Your ref: TR050007  
My ref: DCO/TR050007/HinckleySRFI

7<sup>th</sup> February 2025

**TR050007 Hinckley SRFI– Warwickshire County Council (20040686/HRFI-AFP550 )  
Extension of Time - Comments on Documents Submitted by Applicant 10<sup>th</sup>  
December 2024**

GIBBET LANE NB  
(HGV)

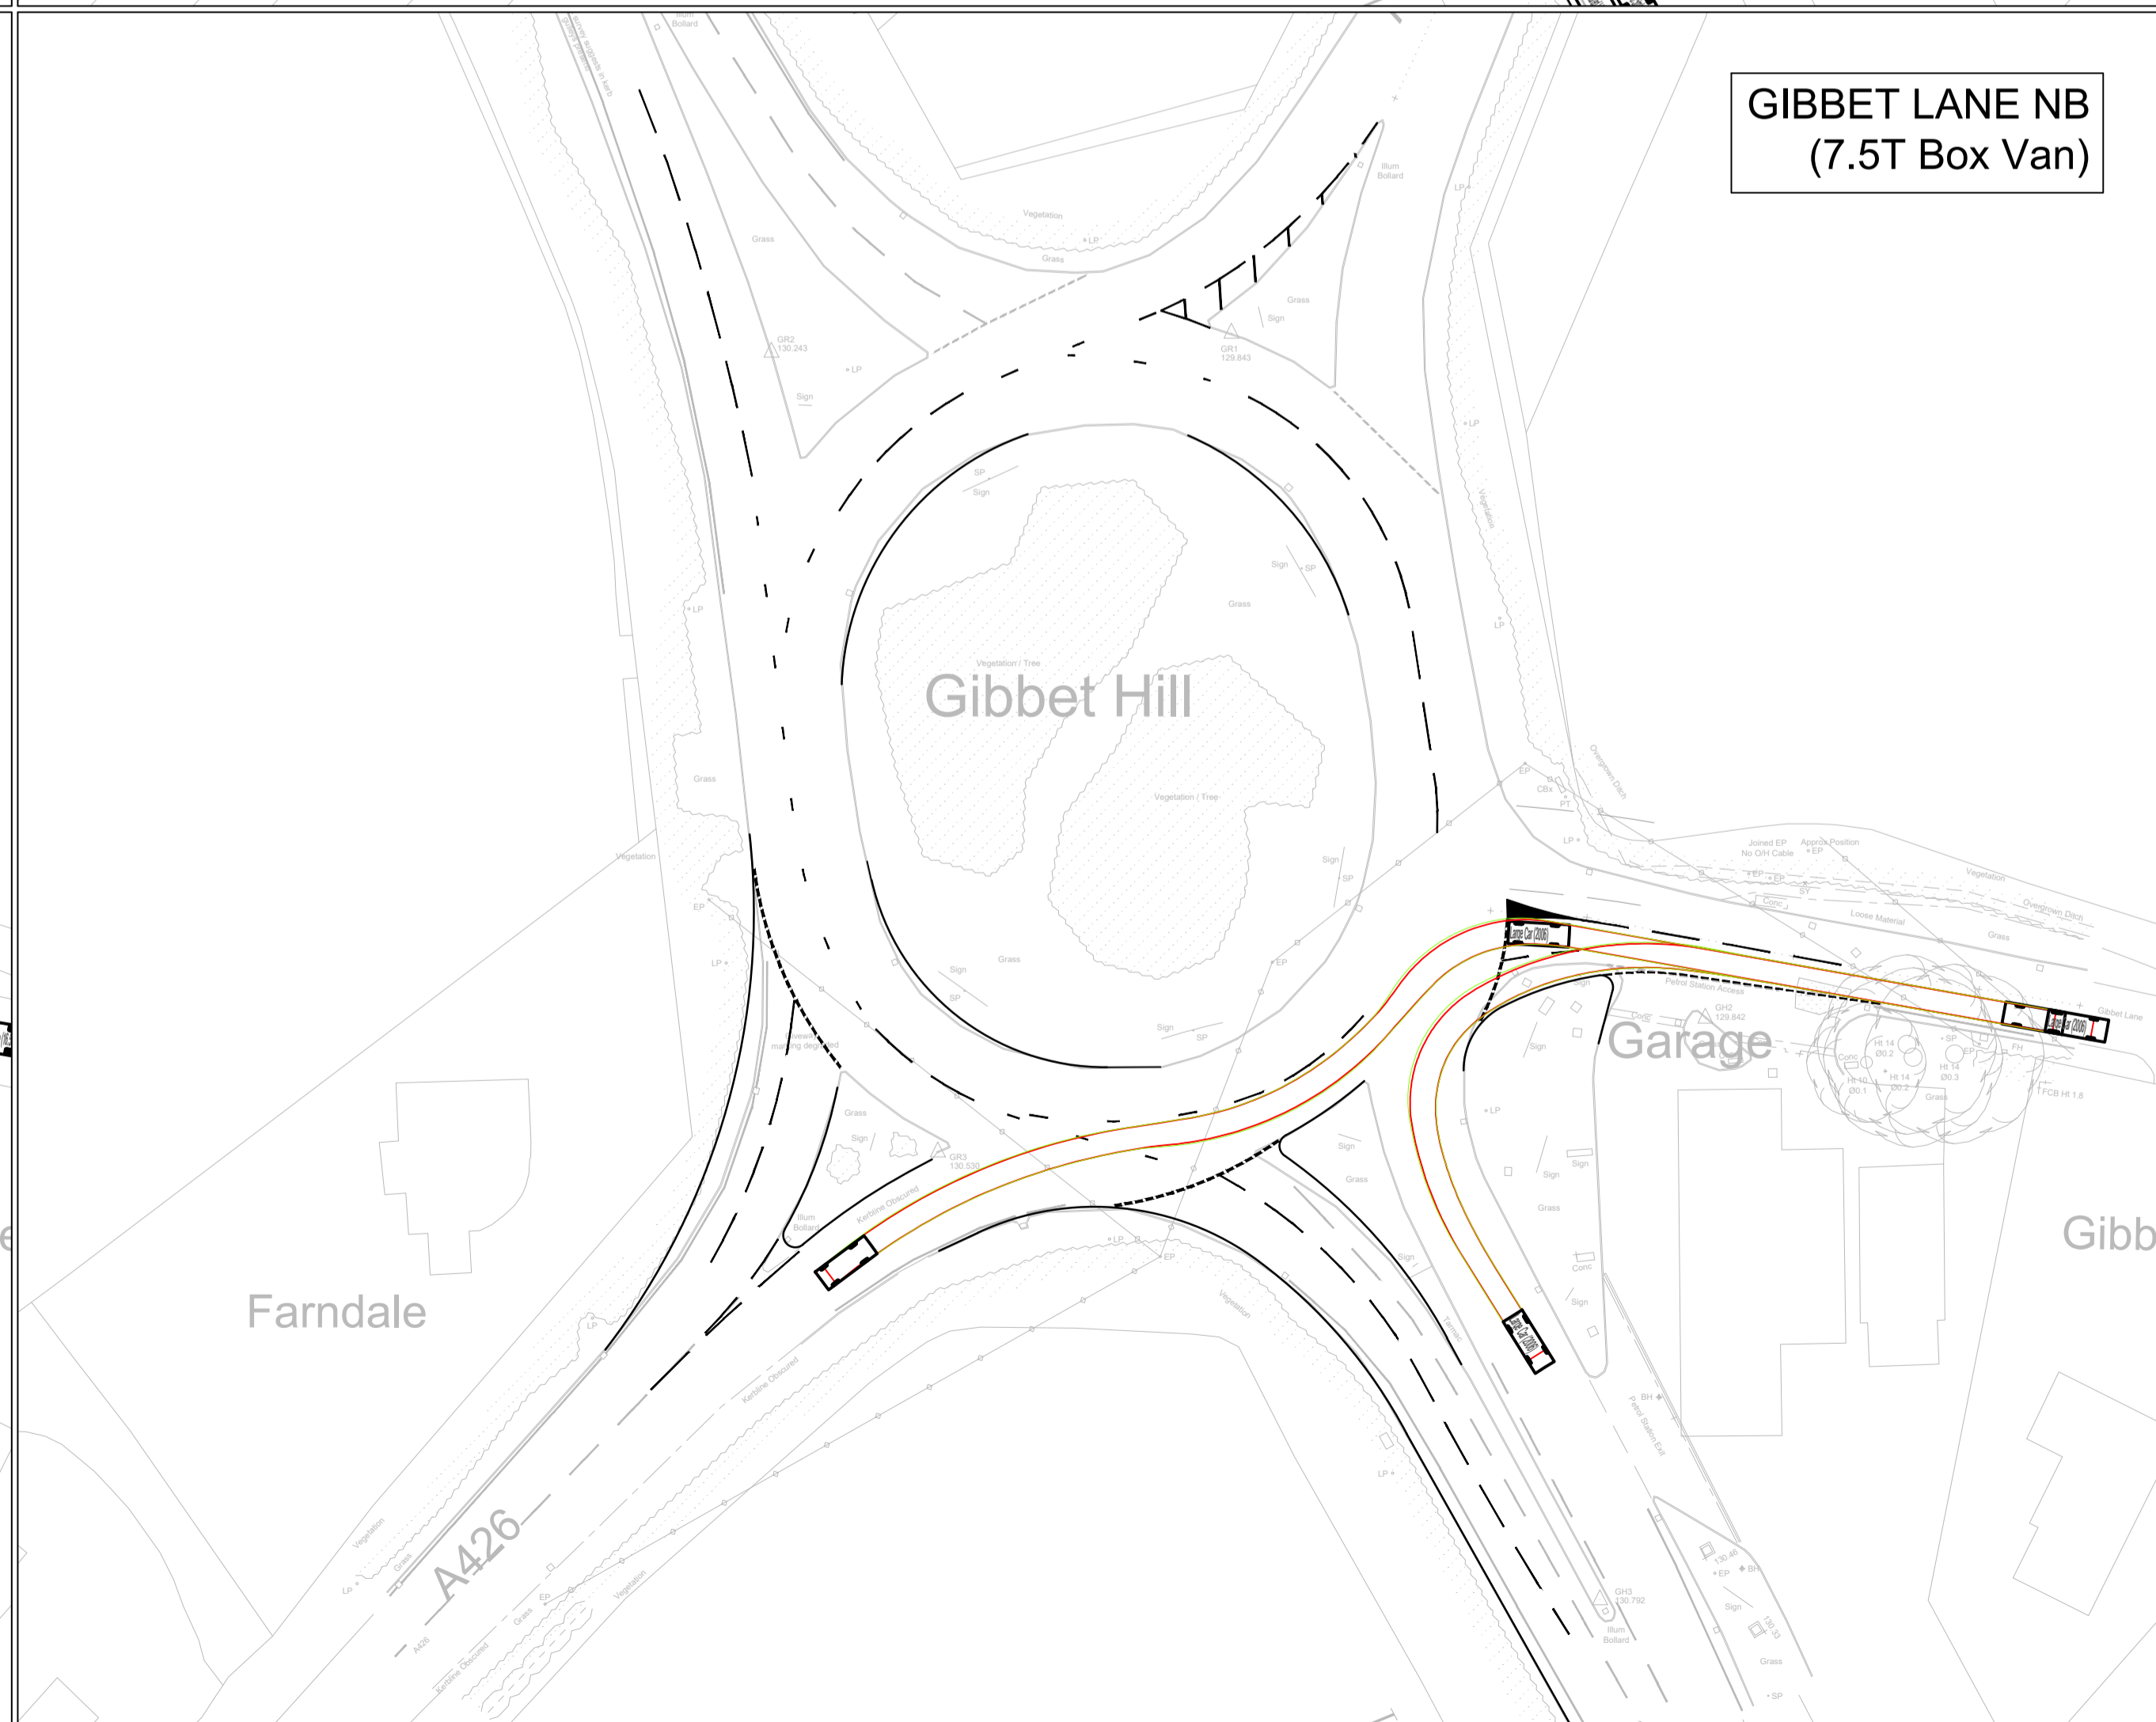
A concern raised by WCC with the proposed design is the swept path tracking. National Highways previously raised a concern over the likelihood either for two HGV's travelling side by side entering the junction and/or travelling around the circulatory carriageway for side swipe incidents to occur. If not addressed as part of the mitigation scheme WCC consider it is likely that HGV's will continue to position centrally on the approaches and on the circulatory to minimise this risk, therefore the mitigation scheme will not deliver the improvements intended. The revised scheme shows some minor kerb changes on the circulatory carriageway and some white lining on the circulatory carriageway. Whilst the swept path drawing referenced in the Road Safety Audit Brief (HRF-BWB-GEN-XX-DR-TR-134) shows the HGVs travelling side by side, the tracking speed used is 15kph (9.3mph), and some of the tracks have used a large number of target points to create the path which may indicate that a smooth and constant driving arc may not be possible in practice. BWB have advised that:

It is considered that HGVs will want to travel faster than 9mph around the circulatory of this reasonably large ICD roundabout, and if they cannot do so safely then they will continue to occupy central positions on the approach lanes and the circulatory. Notwithstanding the above assurance that the speed used is appropriate, if the DCO is consented, swept paths with speeds more commensurate with a large roundabout should be provided as part of the Road Safety Audit, as well as the tracking for semi – trailer HGV's, in order to be assured that an agreed mitigation scheme will be suitable and deliverable.

Other than the above parameters, the design speed to be used for swept path analysis is not stated in the DMRB. However, the swept path analysis was undertaken using the industry standard Autodesk Autotrack software. The software guidance recommends that manual amendments are made to limit turning radius where paths are tested faster than 15km/h due to dynamic effects on the vehicle which are not modelled by the software.

The guidance warns against testing above 15kph as adjustments should then be made to the dynamic effects (weight shift, tyre grip, roll over effect and a number of variables per vehicle). The guidance then goes onto warn: "The pre-defined dynamic values used in these dynamic settings are taken from AASHTO and TAC handbooks are intended for use with normal road vehicles, i.e. cars, lorries etc. If your vehicle is very large, e.g an aircraft or very small then they may not be appropriate, or you may need to define custom values".

Vehicle tracking is a constant speed analysis whereas in reality, vehicles will slow down at the entry to the roundabout and then speed up again at the exit. Adjusting the speed variable only effects the steering input applied over a certain distance as steering is applied at a fixed, constant rate. Therefore, at higher speeds, vehicles travel further while steering angle is being applied. The vehicle speed setting does not affect the amount of space required for a vehicle to undertake a given manoeuvre.

Therefore, the speed used in the swept path analysis is appropriate and altering this speed would have negligible effect on the design.
